Subject: FW: LU/274/21/DoC - 2 Croft Cottages, Littlehampton, BN17 5LS

Further to the applicant's e-mail of 17 February 2022, Environmental Health can confirm that the submission is acceptable for the discharge of Part 3 of condition 9 of LU/159/19/PL and we look forward to receipt of the post-remedial Verification Report in relation to Part 4 of the same condition.

Condition 9.3

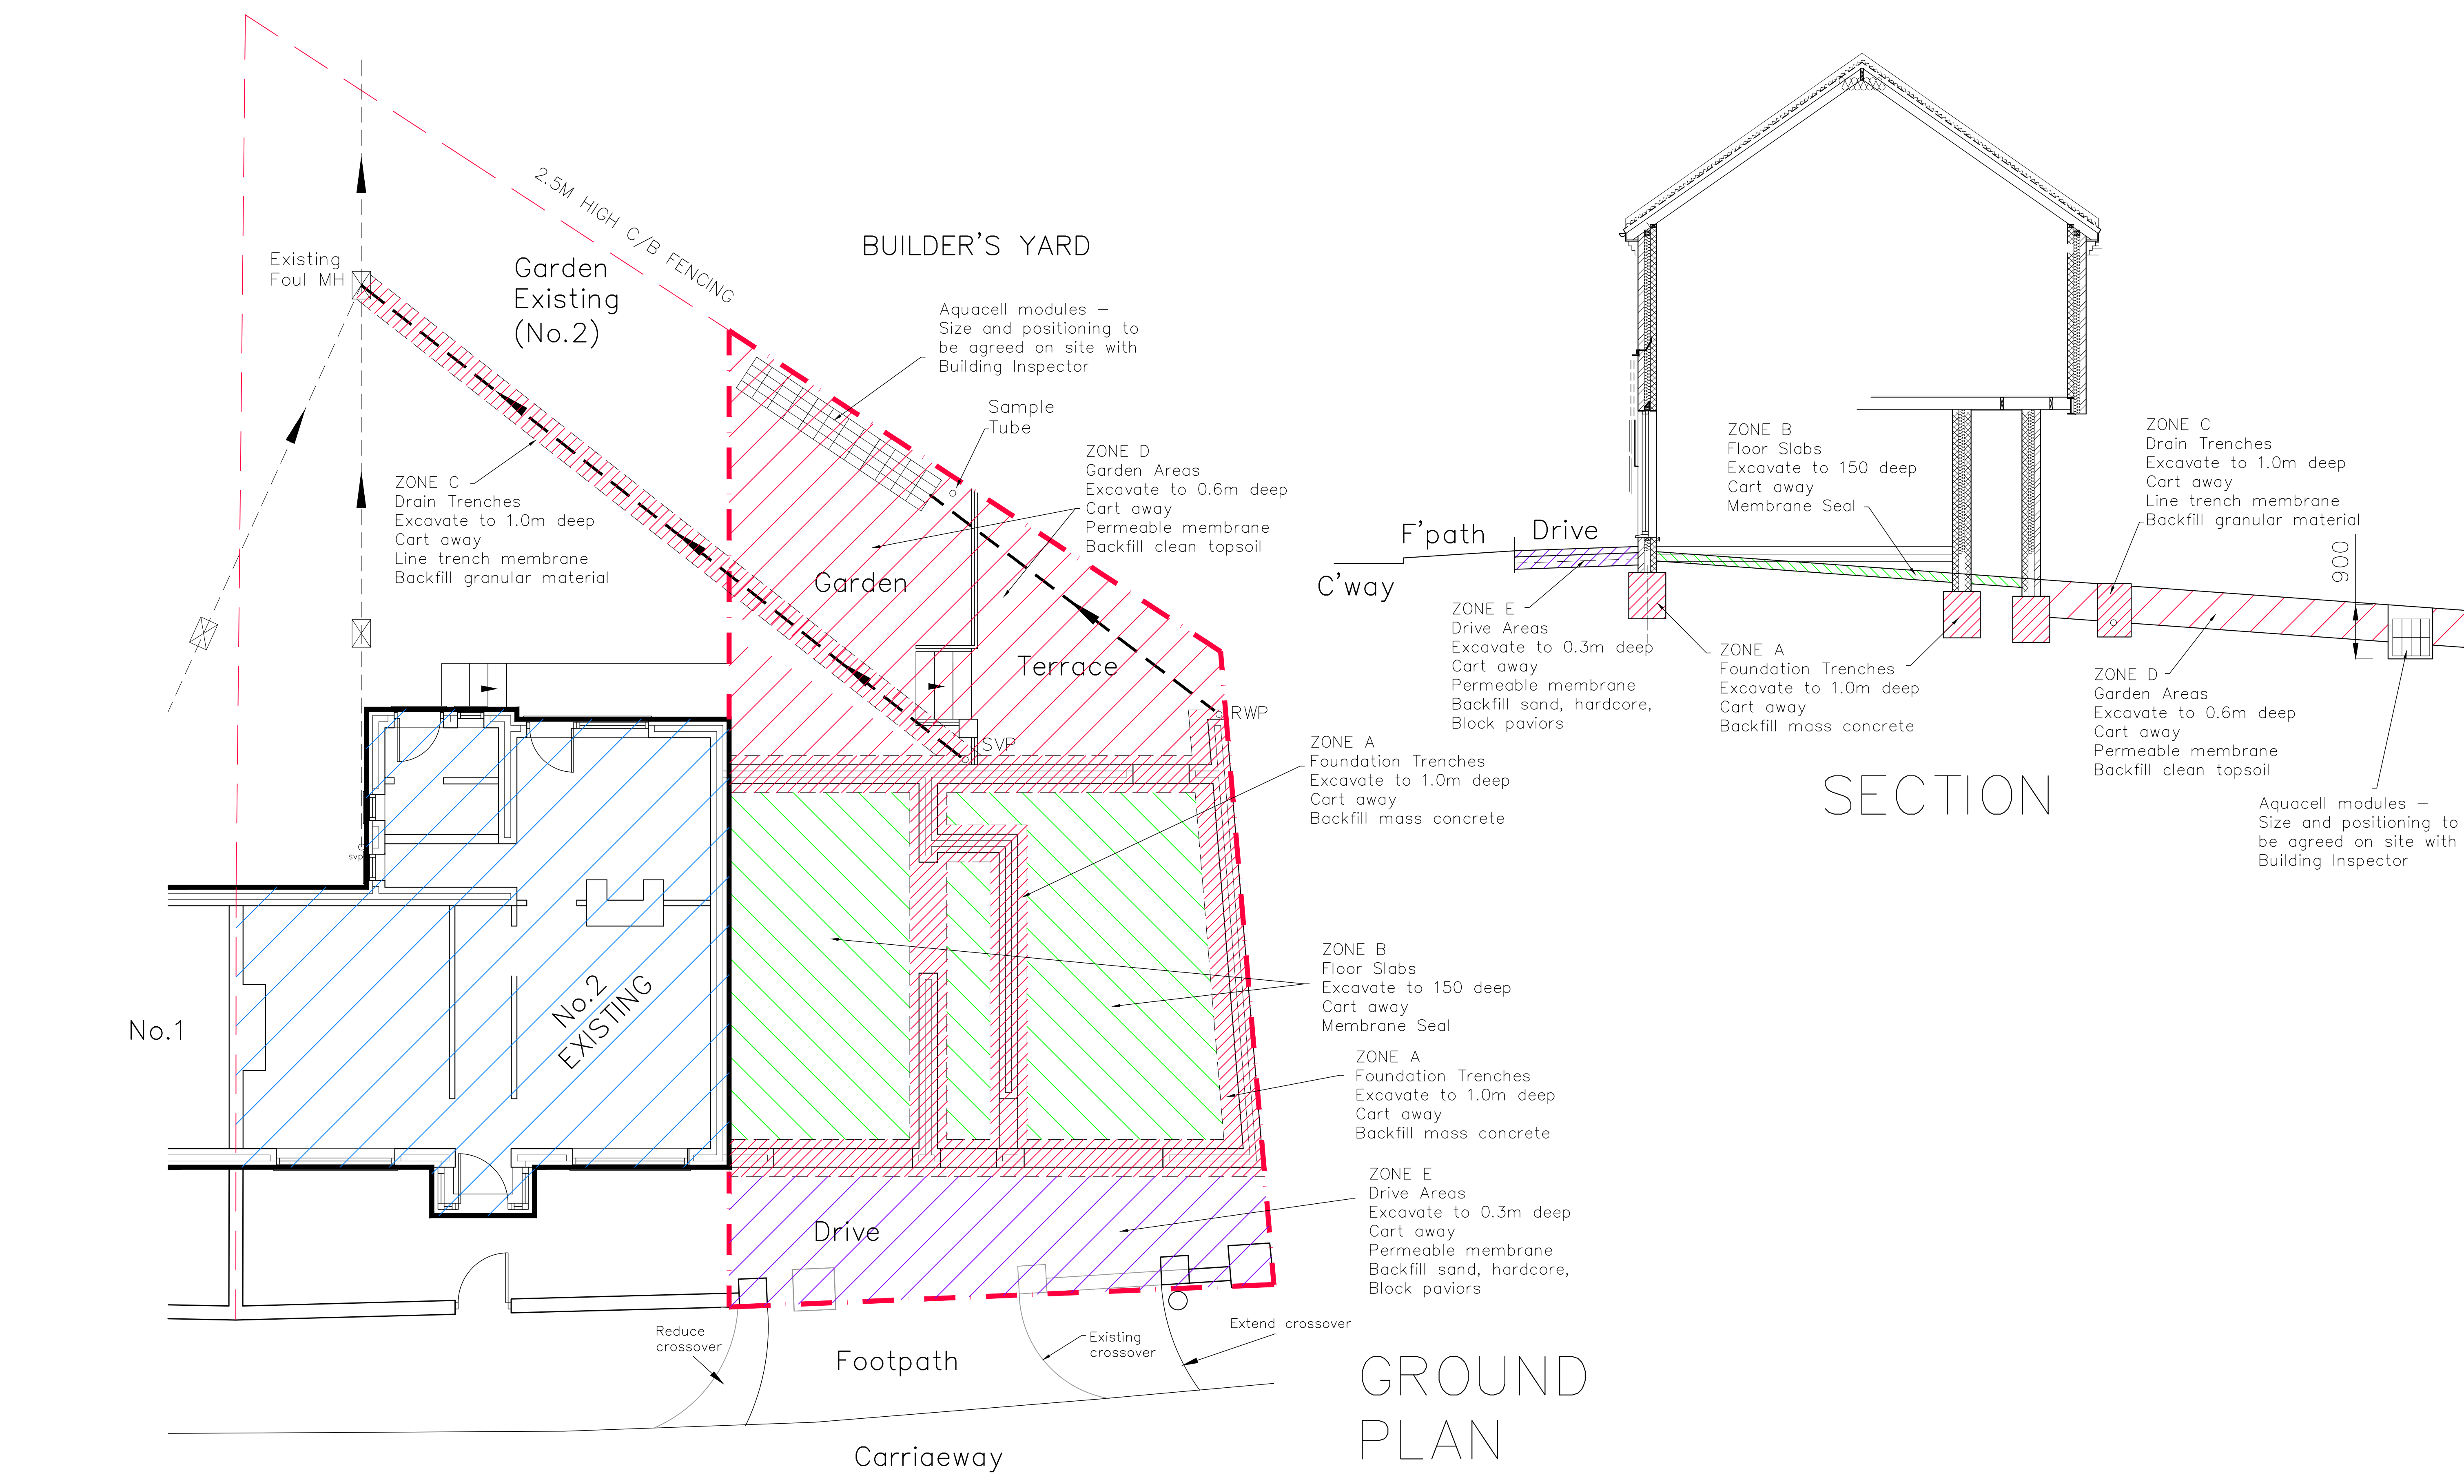
We confirm that our client has agreed to include a 'no-dig' membrane in the form of a hi-vis non-woven geotextile membrane in the areas of parking/hardstanding/terrace in order to provide an obvious warning signal for future contractors and occupants. Our drawing 19023-407D is attached with the membrane notation included. Typical details of the membrane proposed are attached.
